From: Sue Howell
Sent: 23 July 2018 14:26
To: Planning.Responses
Cc: Simon Davis
Subject: RE: Planning Consultation on: BE/51/18/PL

Comment from Greenspace

2018
Site Address: Springfields Chichester Road Bersted PO21 5EE
Grid Reference: 491534 101803
Description of Works: 1 No. dwelling. This application is a Departure from the Development Plan.

BS 5837:2012-Tree Constraints plan.
[Filename]

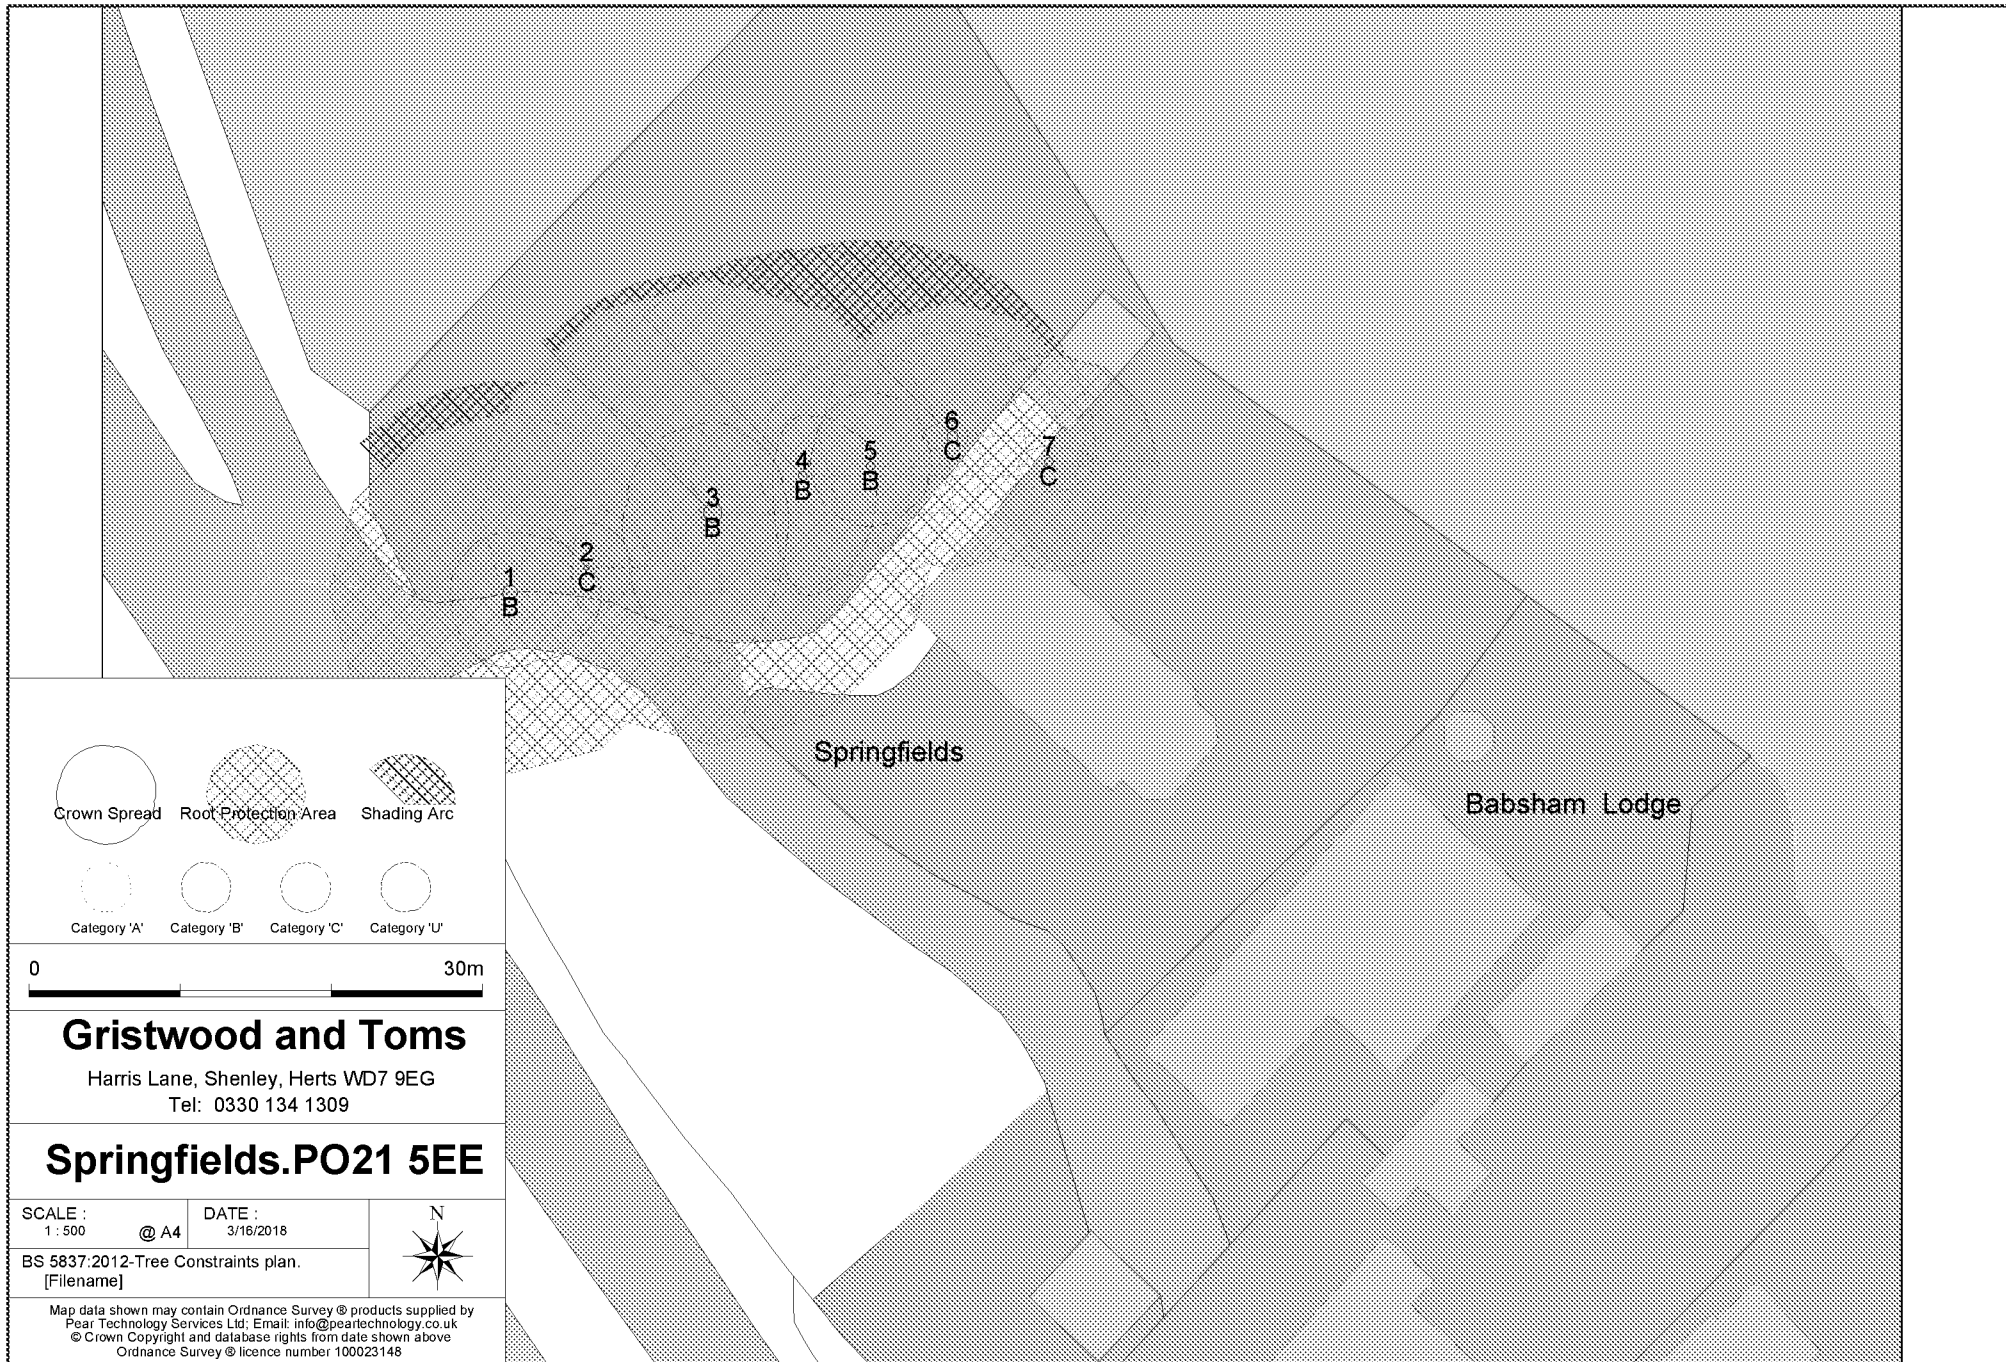
No landscape objection to the proposals however of note are the trees on this site which will require appropriate tree protection which conforms to BS5837:2012 Trees in relation to design, demolition and construction -- Recommendations.

Greening of any new development will be required to ensure that the dwelling incorporates into its environment and semi-rural setting and to ensure that tree protection measures have been considered. The planting proposals should be submitted in plan form along with trees and vegetation to be retained so that a clear picture of the proposals can be seen.
